Subject: Consultation Response 2023/91491 Prickleden Mills, Woodhead Road, Holmfirth
Date: 28 June 2023 11:20:51

Consultation Response 2023/91491 Prickleden Mills, Woodhead Road, Holmfirth

Figure 5.4 **Location of Undercroft Car Park**

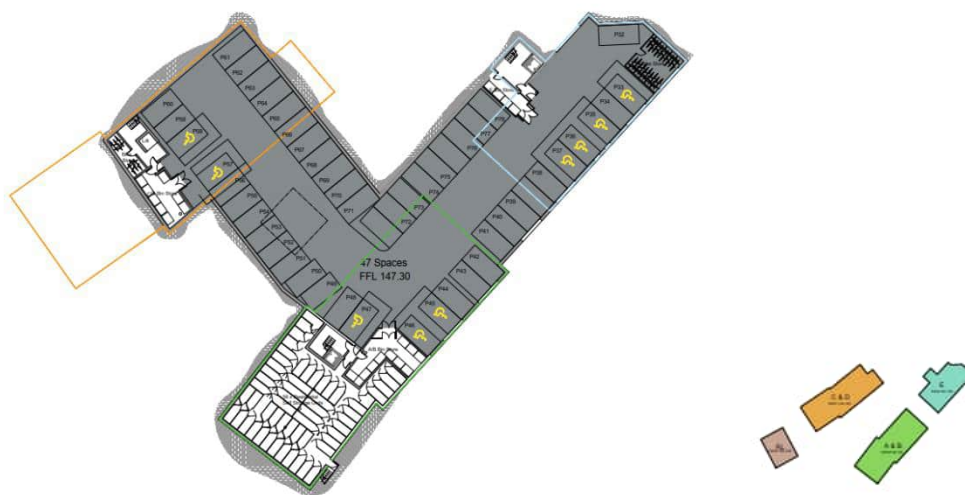
The proposal for the below ground parking will place this feature in the area of the former secondary smaller pond. It is not known if this feature was removed or backfilled when it was taken out of use. The former smaller pond will have had water channels entering and leaving the pond and these channels will have taken water to the former water wheels that were once on the site. The location of these former features and their design is uncertain. The excavations for the new below ground parking could therefore impact on the former water power features. These water power features are late in date for their construction and their design and construction is uncertain. The proposed below ground parking could therefore impact on these remains.

The proposed development may impact on buried remains relating to the use of water power on the site. I would recommend that a programme of archaeological works is undertaken to monitor the excavation of the below ground parking croft to record any water power features exposed by the excavations. This should be undertaken by an archaeological watching brief during the excavation of the proposed below ground car parking.

"No development to take place within the area indicated until the applicant, or their agents or successors in title, has secured the implementation of a programme of archaeological recording. This recording must be carried out by an appropriately qualified and experienced archaeological organisation or consultant, in accordance with a written scheme of investigation which has been submitted by the applicant and approved in writing by the Local Planning Authority."
